**Consultation Response from KC,
Highways Development Management****2023/90209 Land off, Thornhill Road, Dewsbury, WF12 9QE****Erection of detached dwelling and two storey workshops****Date Responded: 14-3-2022.****Responding Officer: Mark Berry****Responding Ref: 15-1NW-11**

Highways Development Management comments as follows:

Description
PROPOSED COMMERCIAL UNITS PLANS & ELEVATIONS

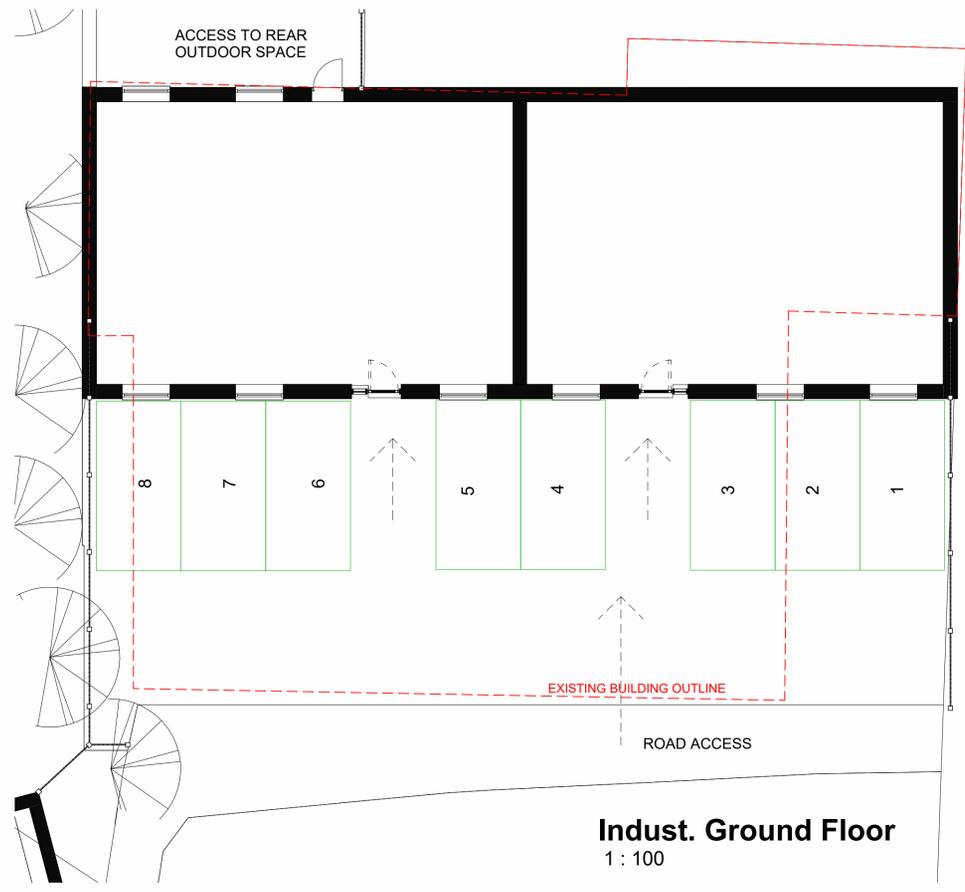
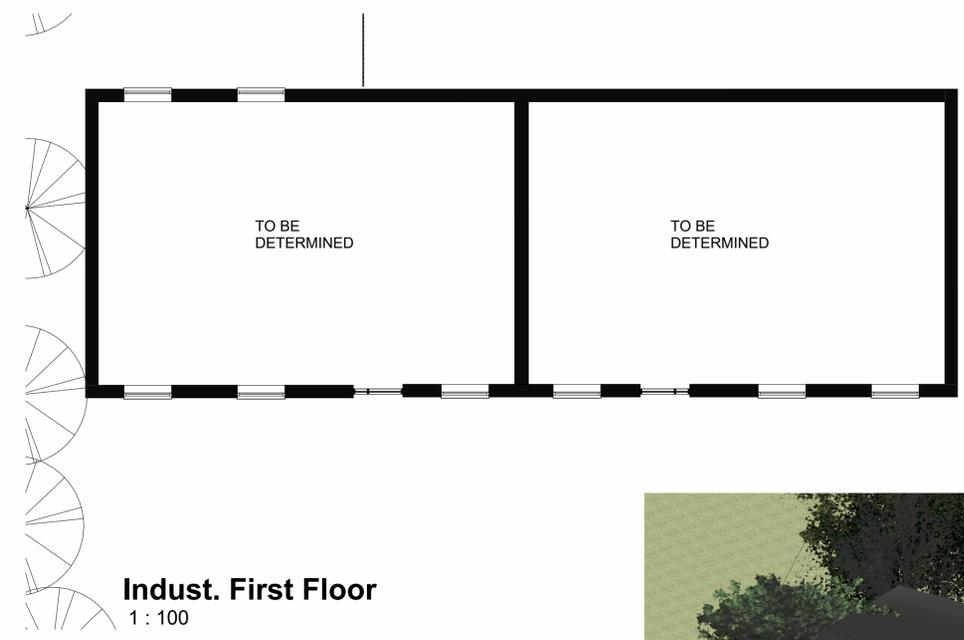
1, As stated above the existing workshops have insufficient off-street parking and cars visiting the business, or being repaired, park in the area to the front of the units and spill out onto the highway which creates highway safety issues, HDM would not want to see this situation repeated with the new development.

Can the applicants be asked to clearly show the parking to the new dwelling and provide a justification for the number of parking spaces to the new industrial units.
